From: Sarah Burrow <Sarah.Burrow@arun.gov.uk>
Sent: 11 August 2021 11:49
To: Planning.Responses <Planning.Responses@arun.gov.uk>
Cc: Anita Gardner <Anita.Gardner@arun.gov.uk>
Subject: RE: Planning Consultation on: M/92/21/PL

Engineers Comments Regarding Surface Water Drainage

Application No: M/92/21/PL
Registered: 6th July 2021
Site Address: 68 Ancton Way Elmer Middleton-On-Sea PO22 6JP
Grid Reference: 498741 100378
Description of Works: Demolition of existing bungalow & construction of 1 No 2-storey dwelling with access & off road parking. This site is in CIL Zone 4 & is CIL Liable as new dwelling.

PROPOSED PLOT PLAN

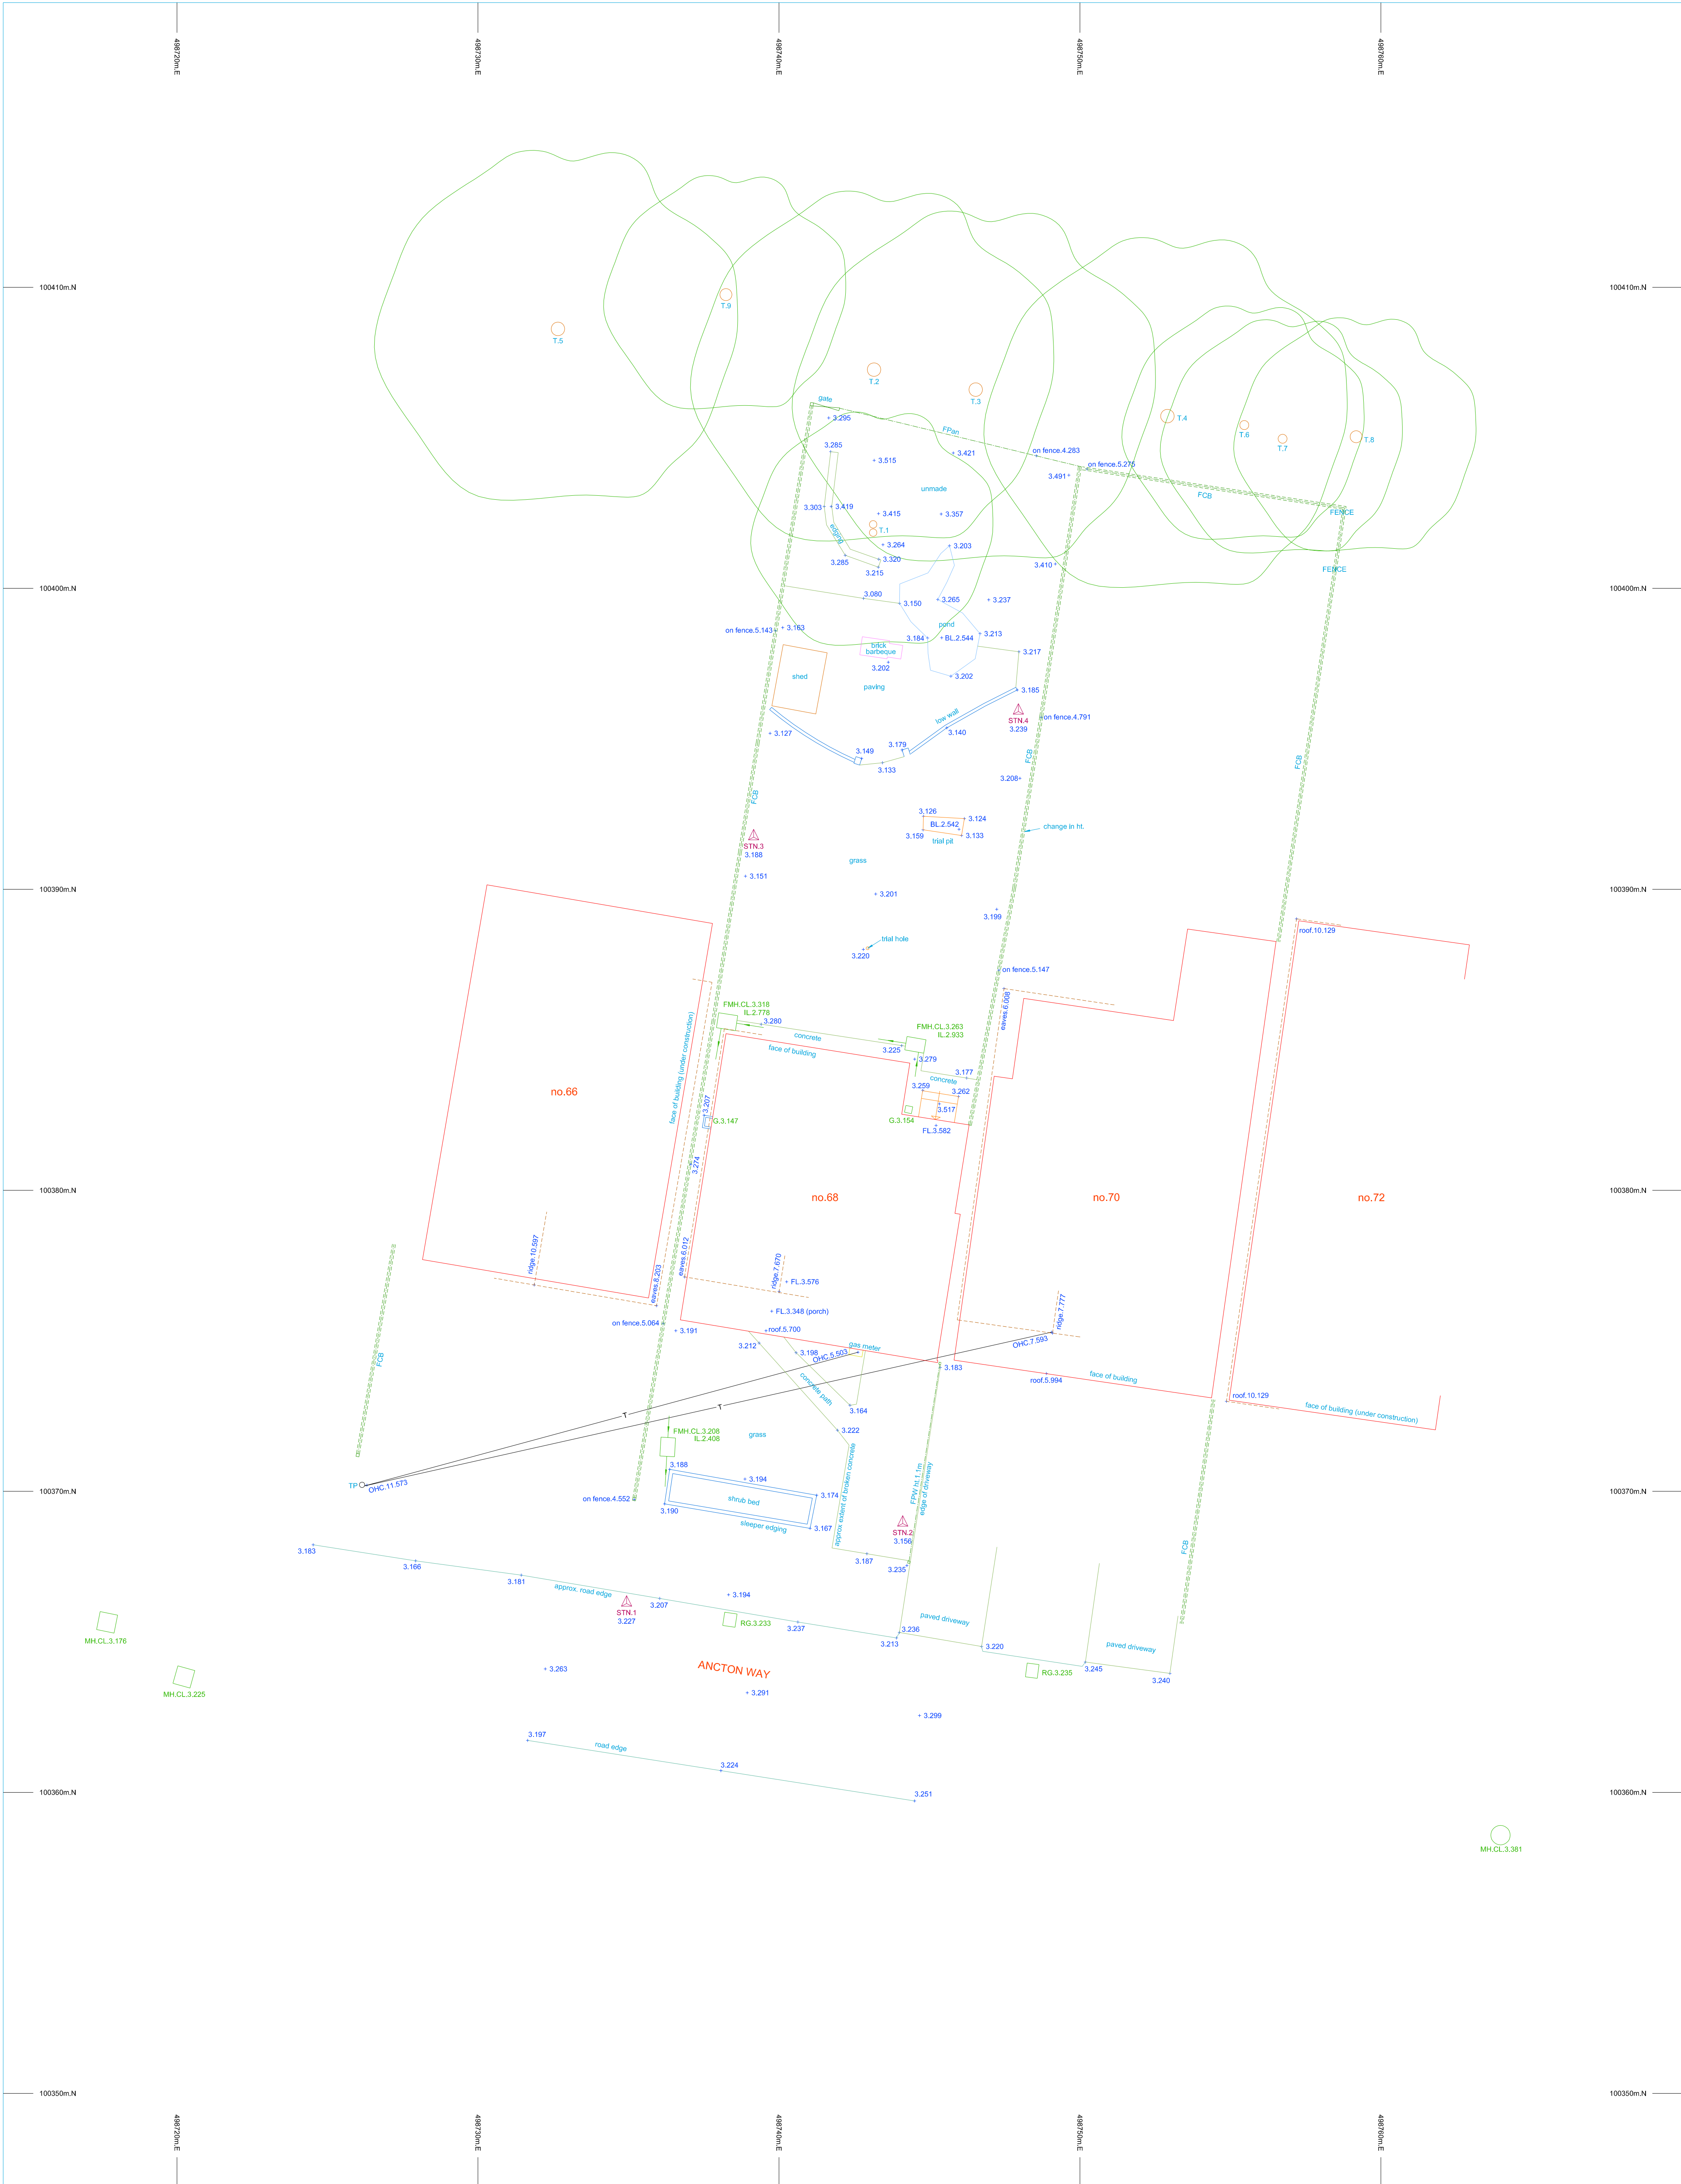
No surface water drainage design has been submitted with this application. The applicant has indicated an intention to drain surface water via soakaway, this must be located **5m** from the building. If infiltration is found to not be viable then there are few alternative options to drain surface water from the site. We will not support a proposed connection of surface water to the foul sewer under any circumstances if this is the case.

If you are minded to approve this application please apply standard condition PCENG2 to ensure that the development is adequately drained and does not increase flood risk elsewhere.

"Development shall not commence, other than works of site survey and investigation, until full details of the proposed surface water drainage scheme have been submitted to and approved in writing by the Local Planning

Authority. The design should follow the hierarchy of preference for different types of surface water drainage disposal systems as set out in Approved Document H of the Building Regulations, and the recommendations of the SuDS Manual produced by CIRIA. Winter groundwater monitoring to establish highest annual ground water levels and winter Percolation testing to BRE 365, or similar approved, will be required to support the design of any Infiltration drainage. No building / No part of the extended building shall be occupied until the complete surface water drainage system serving the property has been implemented in accordance with the agreed details and the details so agreed shall be maintained in good working order in perpetuity."
